EPC file no COM2030

## ***Legacy Church – Green Mountain Falls: Drainage Revision Memo***

Thank you for discussing the minor changes associated with the Legacy Church – Green Mountain Falls project. The intent of this memo is to discuss the minor revisions made to the site plan and erosion control plan (which will be uploaded in concurrence with this letter), as well as to confirm the adequacy of the current storm sewer and detention pond systems with these revisions.

SHEET
C2.1

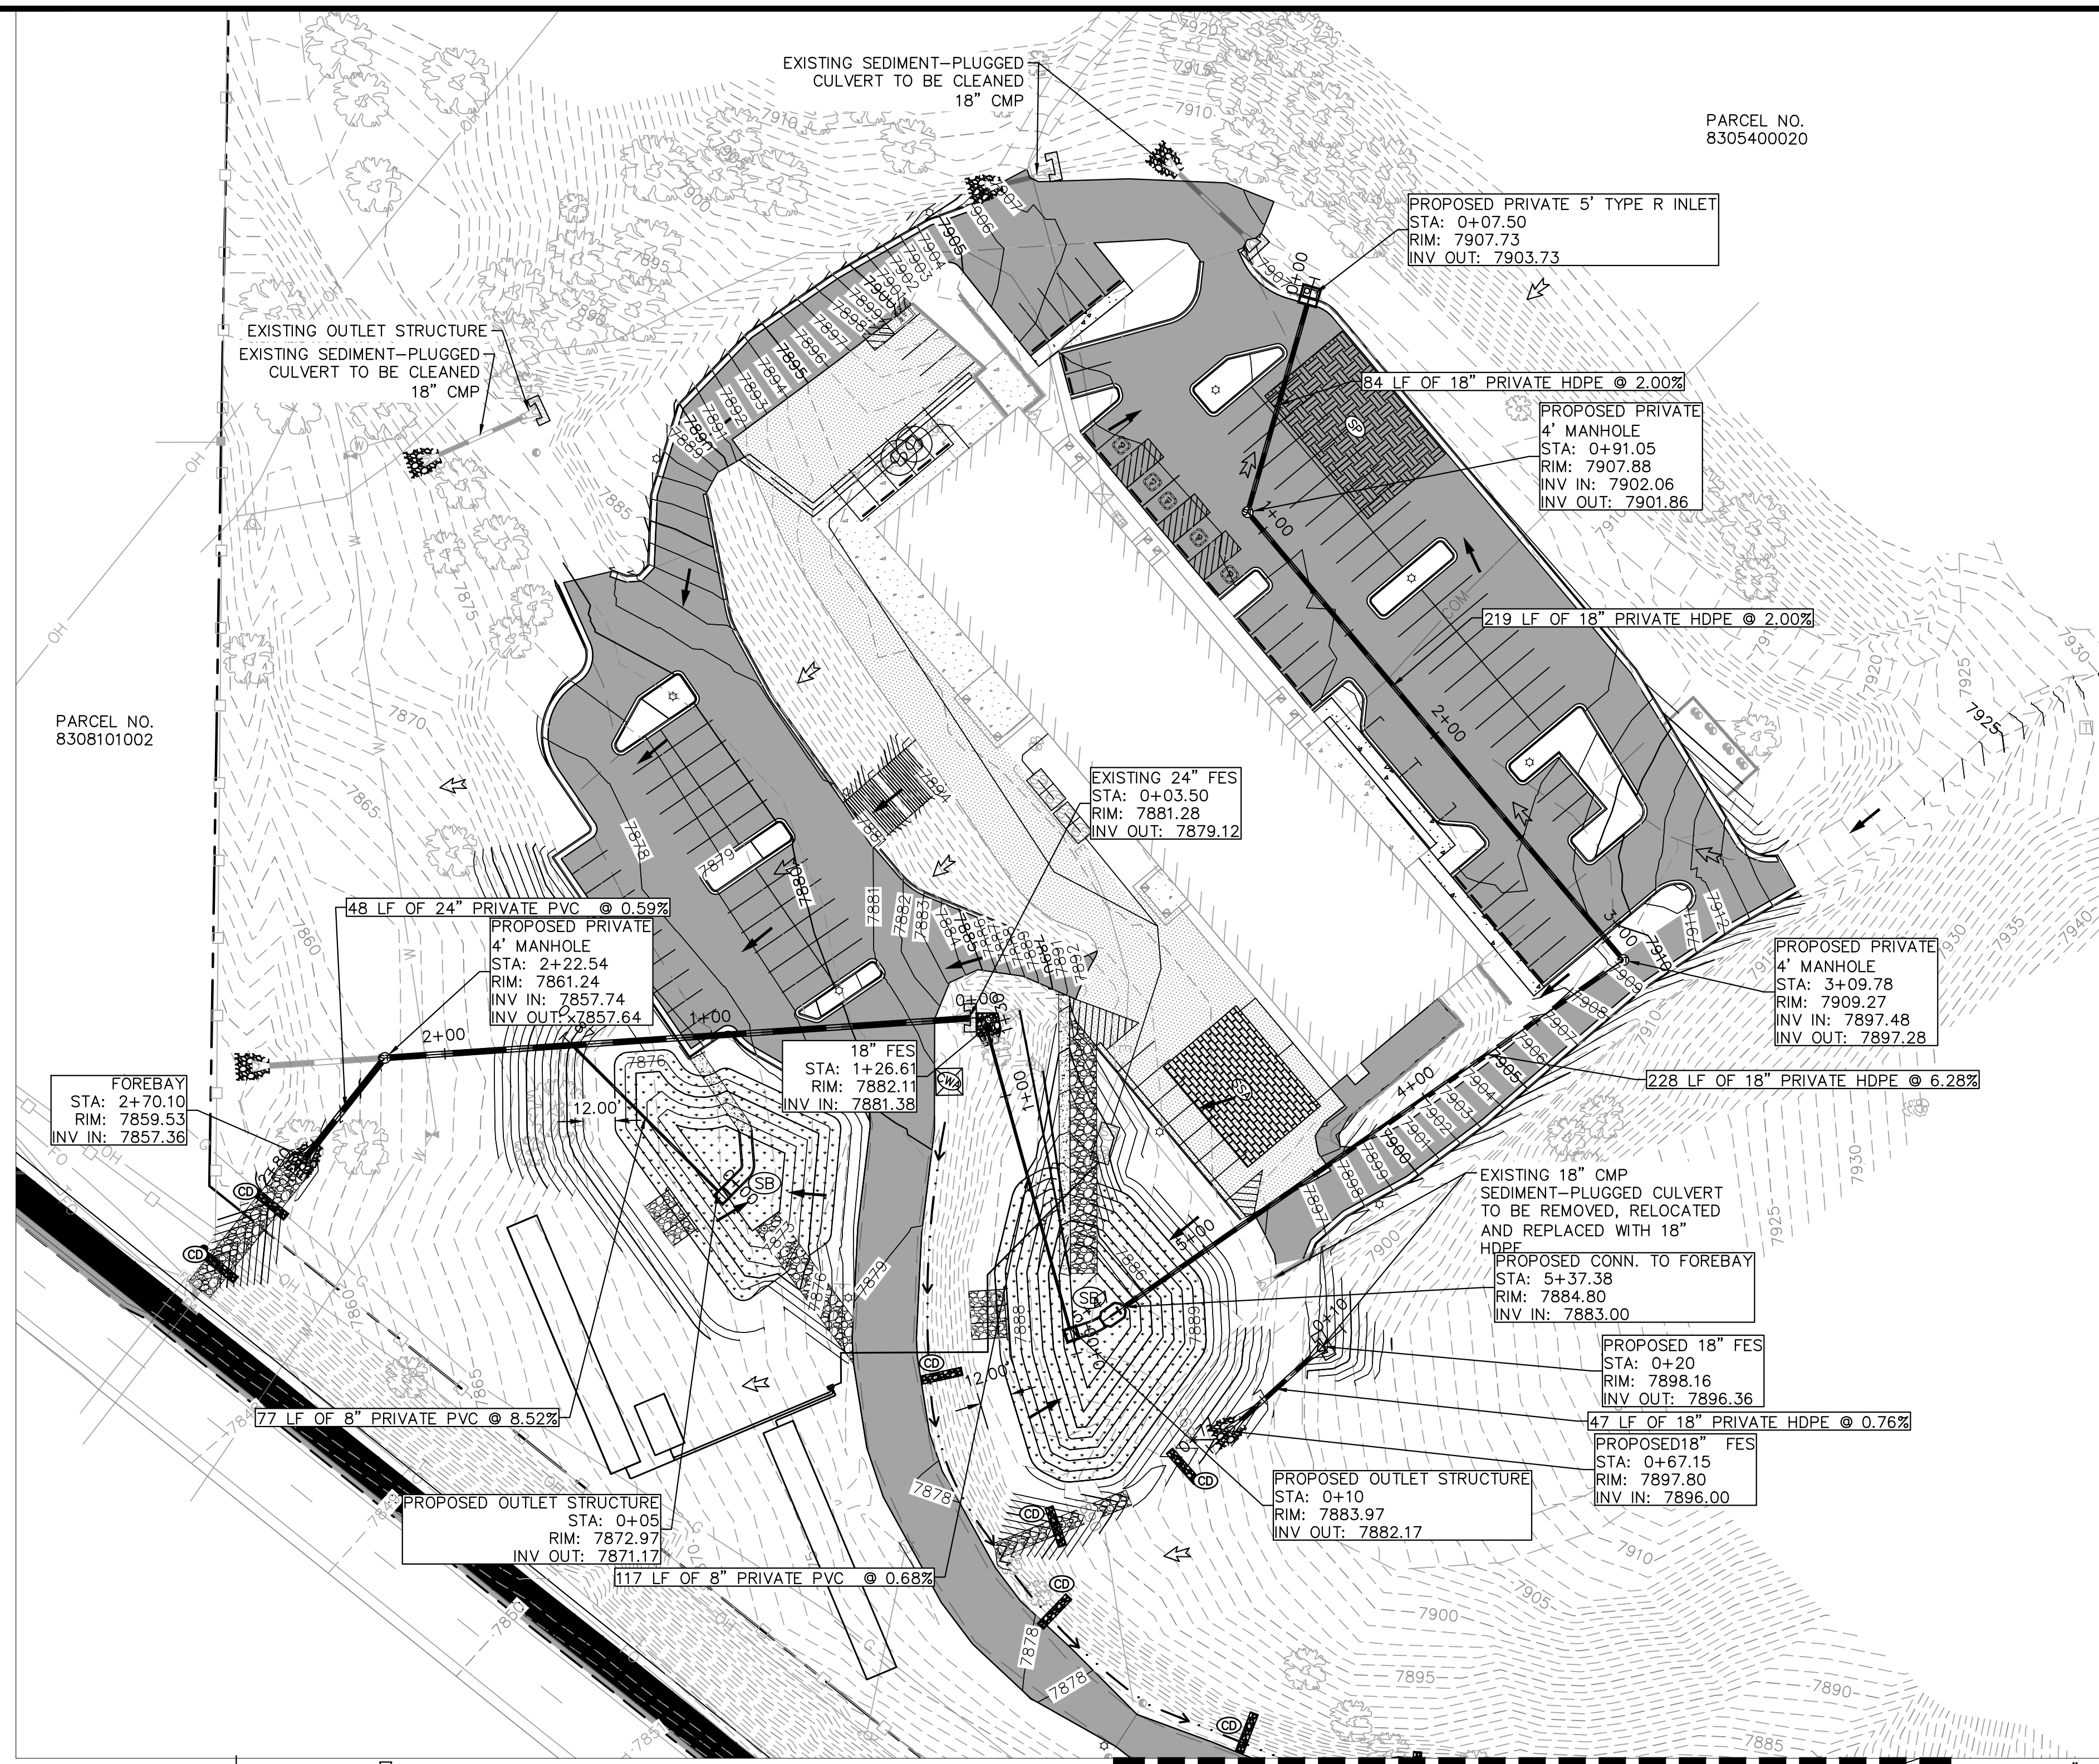
1. The layout of the curb/gutter in a section near the rear of the building has been revised to account for the removal of an existing ground mounted HVAC system. From this change, the net impervious area change was around 20 SF, which would not significantly impact the detention pond system.

4. Curb and gutter has been added along the drive aisle at the bottom of the proposed staircase on the south side of the Site. This does not adversely affect the drainage patterns for this basin.

5. The proposed trash enclosure on the west of the building has been shifted slightly for constructability purposes. With this shift, a 4' concrete crossspan was added to ensure flows do not enter the building and follow existing drainage patterns. An additional 4' concrete crossspan was also added in the northeast drive aisle for the same reasons. All flows are directed to the approved design points and do not add any additional impervious flows.

As designed, the ponds meet all required release rates. With the expansion of a parking island in the rear of the building along the north side of the Site, the overall net impervious area was reduced. Overall, the pond and storm sewer systems are adequate and will operate as designed with the above changes taken into account.

C2.2

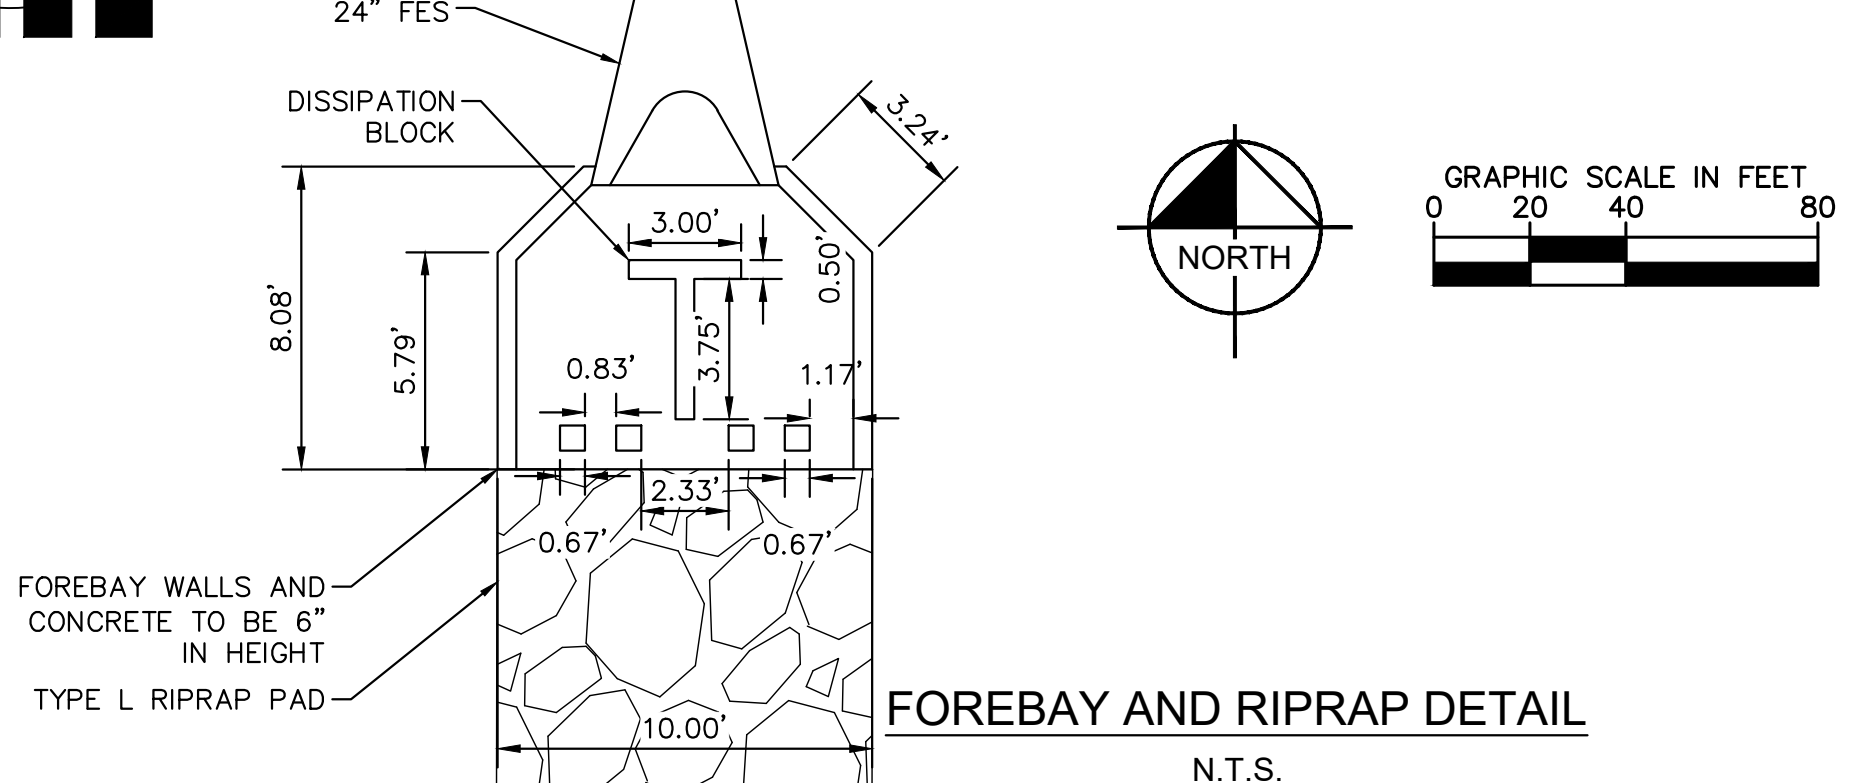
6. Pipes called out as 18" RCP on site has been updated to read 18" HDPE. These updates were made for cost and constructability purposes. These pipe changes do not adversely affect the proposed detention pond and storm design. Additionally, the change in piping will remain adequate for the developed/designed flows on-site.
